From: Anita Gardner
Sent: 08 September 2014 17:34
To: [REDACTED]
Subject: LU/233/14/NMA 36 Clun Road
.....

PROPOSED SIDE ELEVATION 1:50

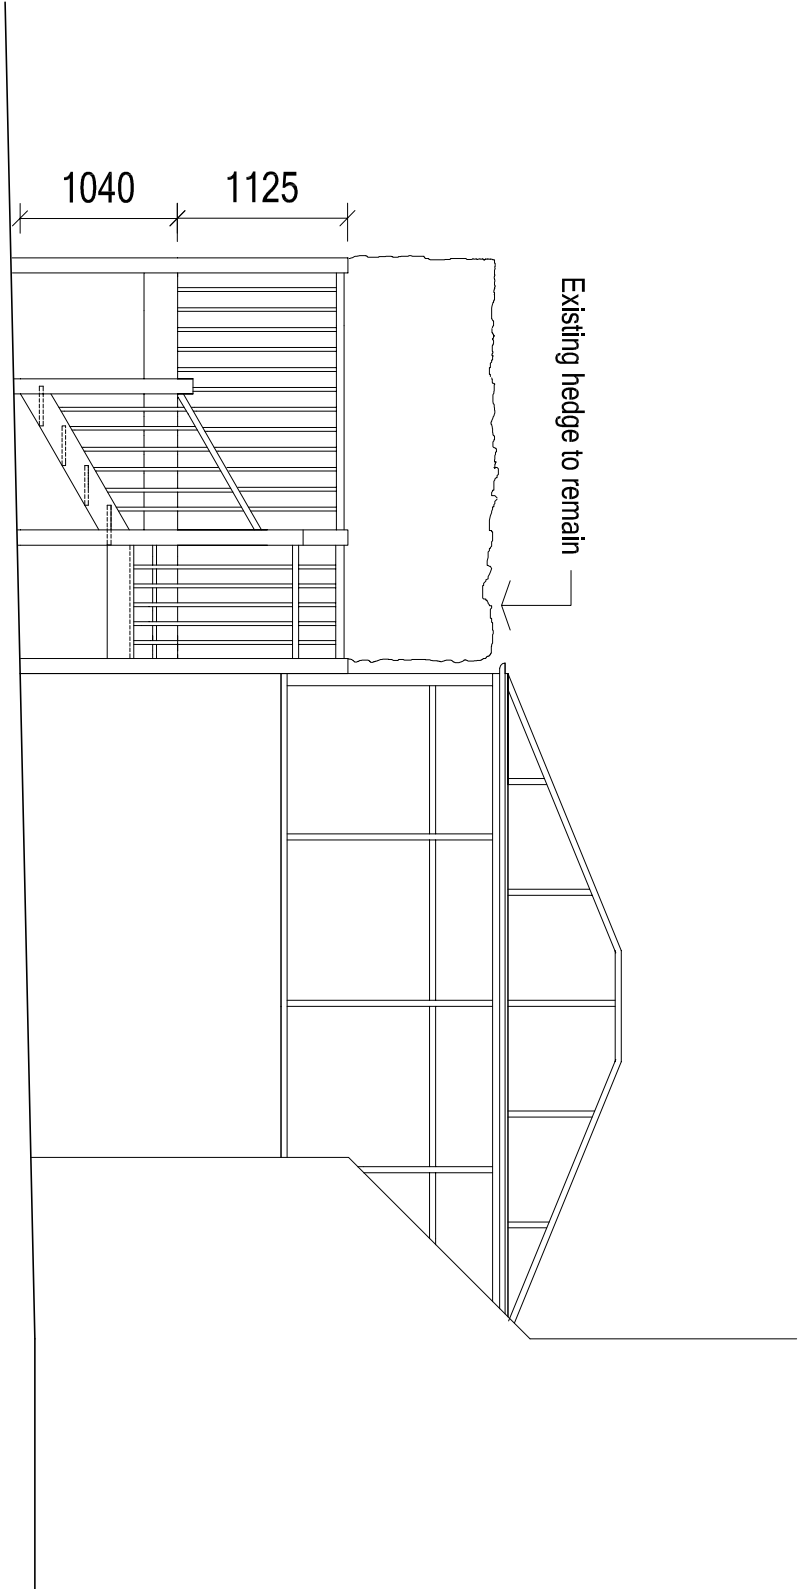
The above application has been passed through to me today. I note that the proposed side elevation and west elevation plans do not indicate the hand rail to the decking in the same position in relation to the existing hedging. The side elevation shows the handrail in line with the hedging and the proposed west elevation extends beyond the edge of the hedging.

Without prejudice, I would appreciate confirmation as to which detail is correct and an amended plan so that both plans accord.
